Planning Application 3/2023/0929 1 Talbot Street

Chipping Parish Council response to Application Ref 3/2023/0929 *Proposed installation of platform lift behind the external coal store to the front; new boundary fence to side of rear garden with angled solar panels.*

Proposed Section Through Site
1 : 100

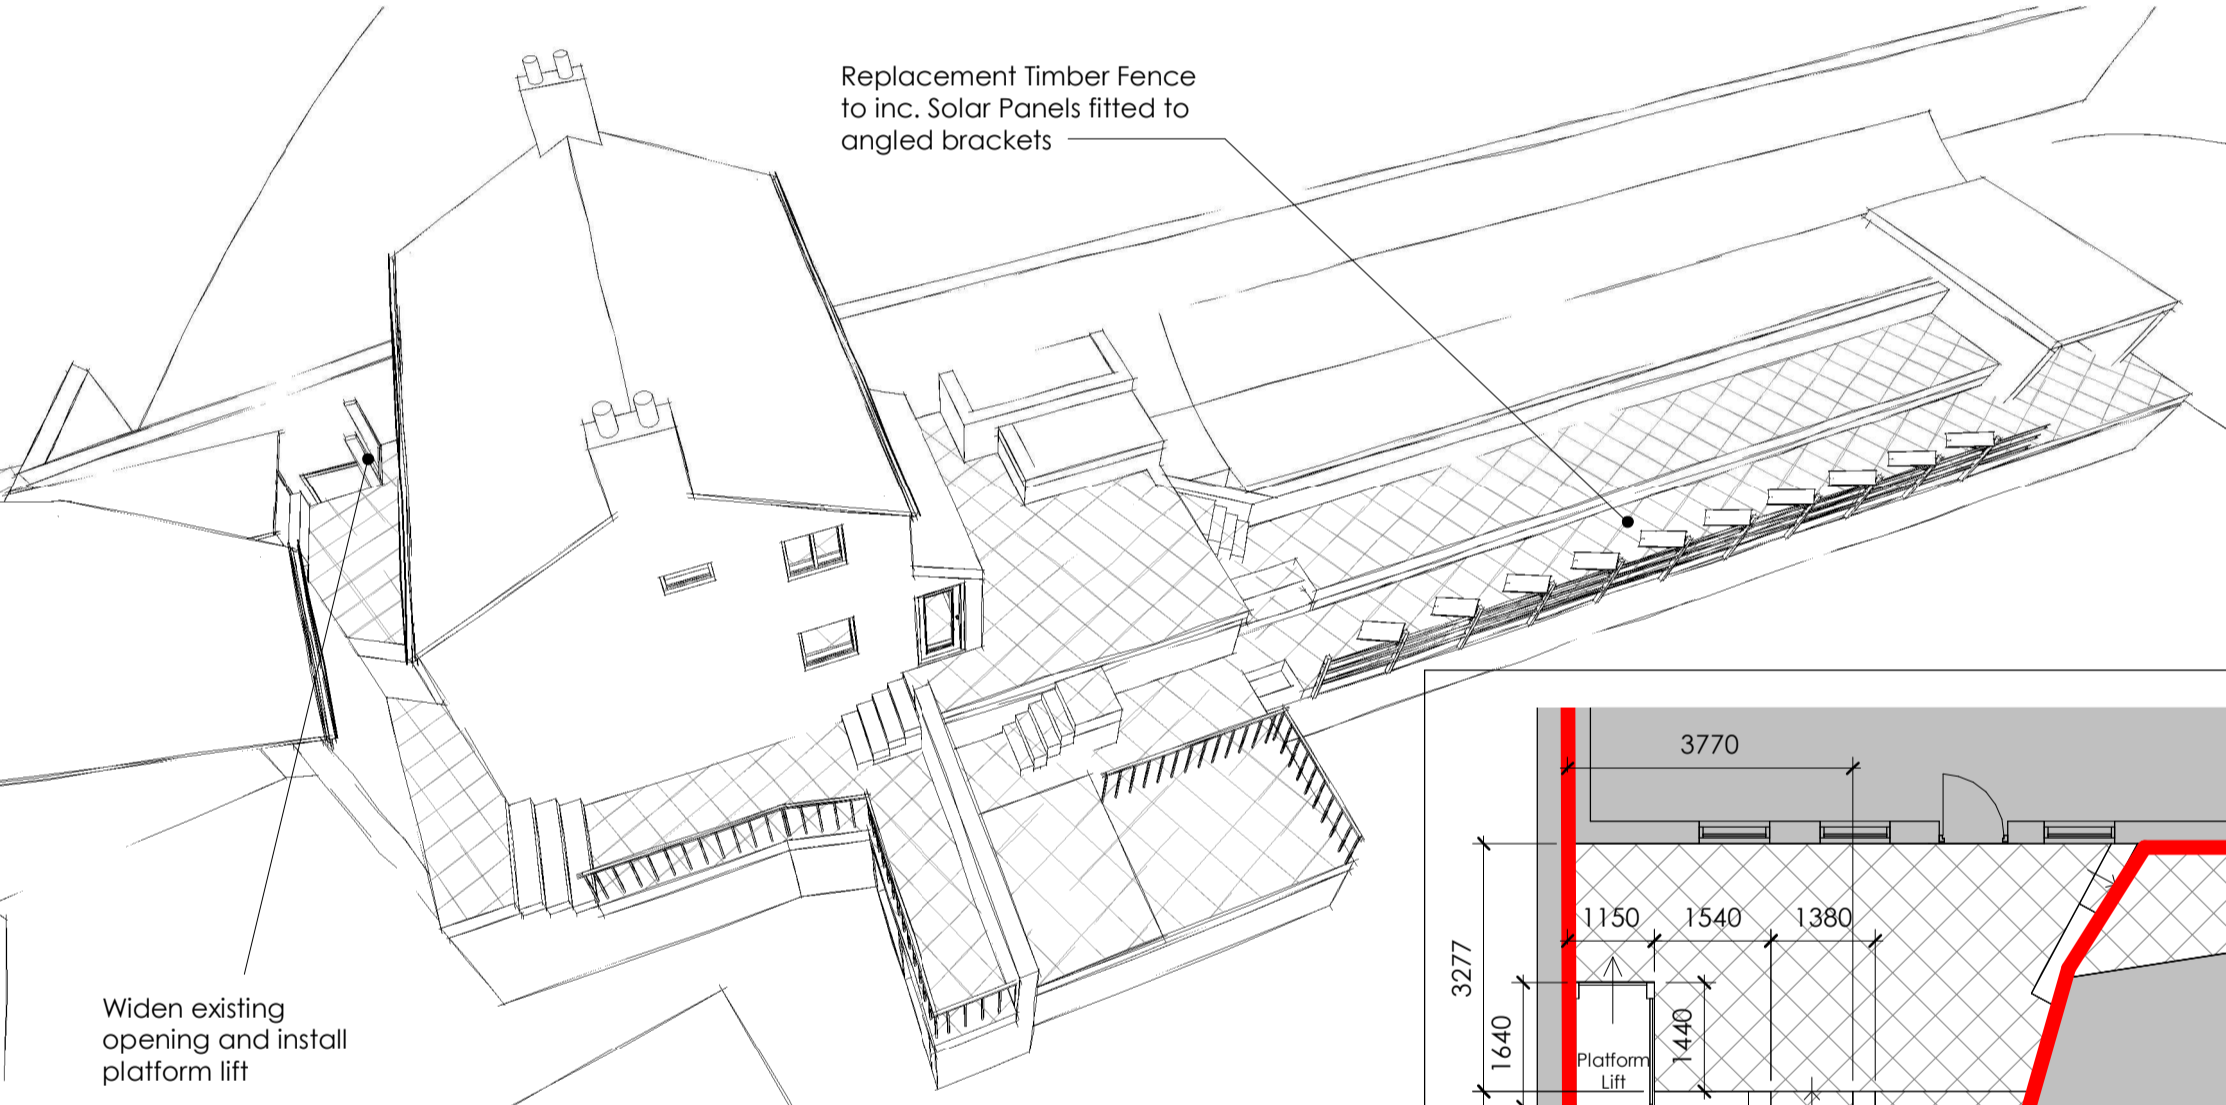
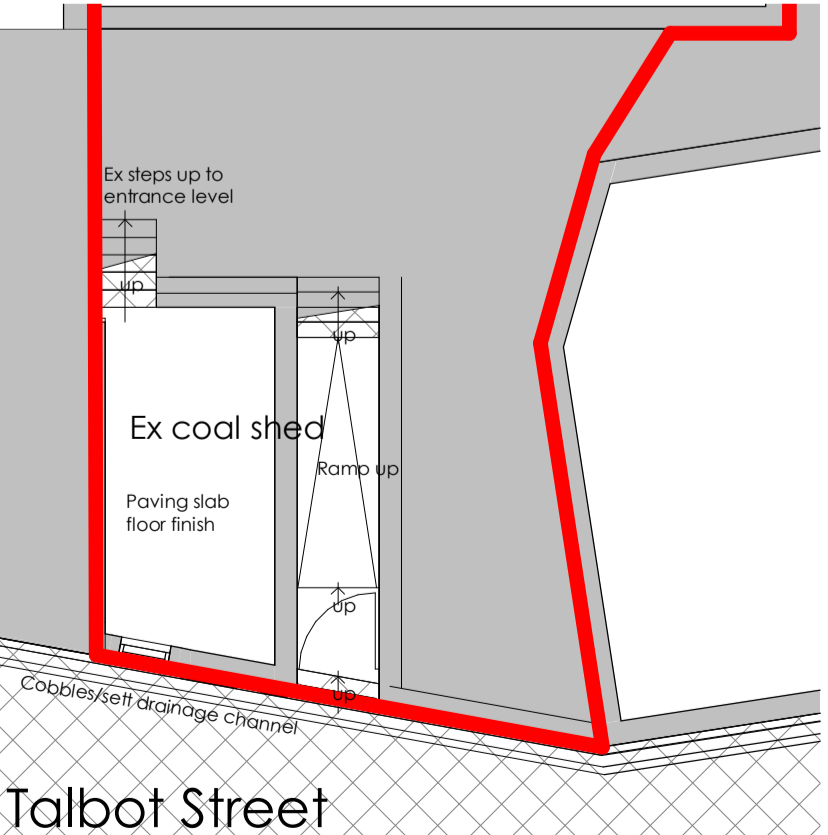
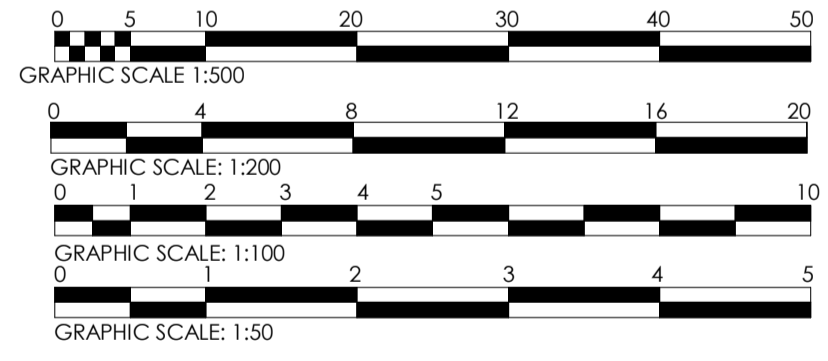
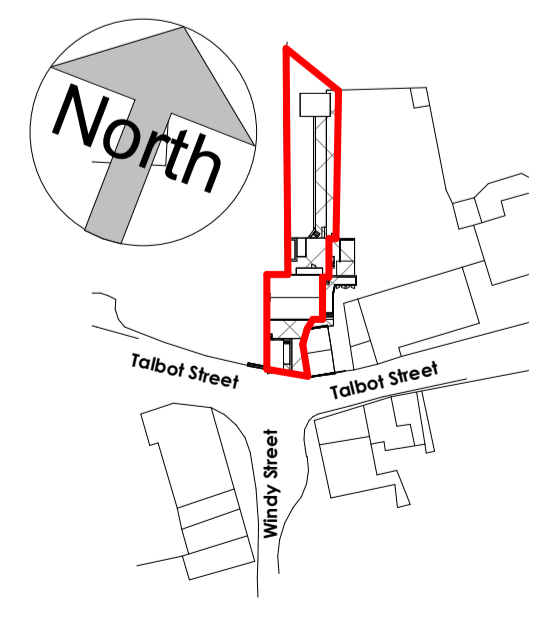
2) The Parish Council broadly supports applications for renewable energy including solar panels as detailed in this application. The Council is however concerned about the visual impact of this proposal on neighbours at the Talbot Hotel and the three properties under development at the Talbot Barn.

Proposed Lift Elevation
1 : 50

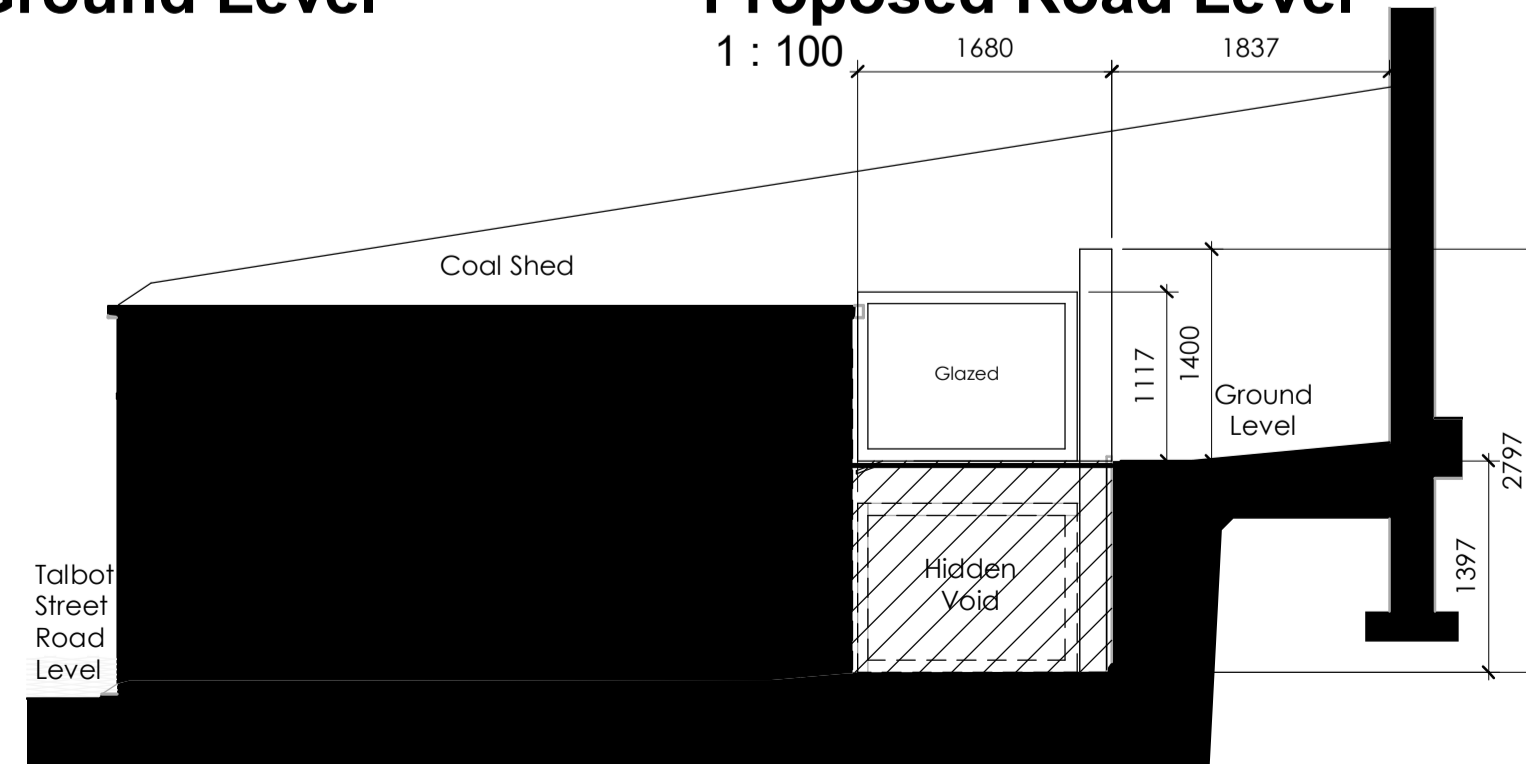
1) The Parish Council is sympathetic to the request to add a platform lift to aid access for occupants with mobility difficulties at 1 Talbot St. This application is linked to Application Ref 3/2023/0219 *Lawful Development Certificate for retention of pedestrian access to Talbot Street via stone shed at the front of the property* which would need to be granted to allow access through the coal store to the proposed lift. It appears from the documents accompanying the application that the platform lift will be barely visible from the street and if painted black would not have an adverse impact on the street scene.
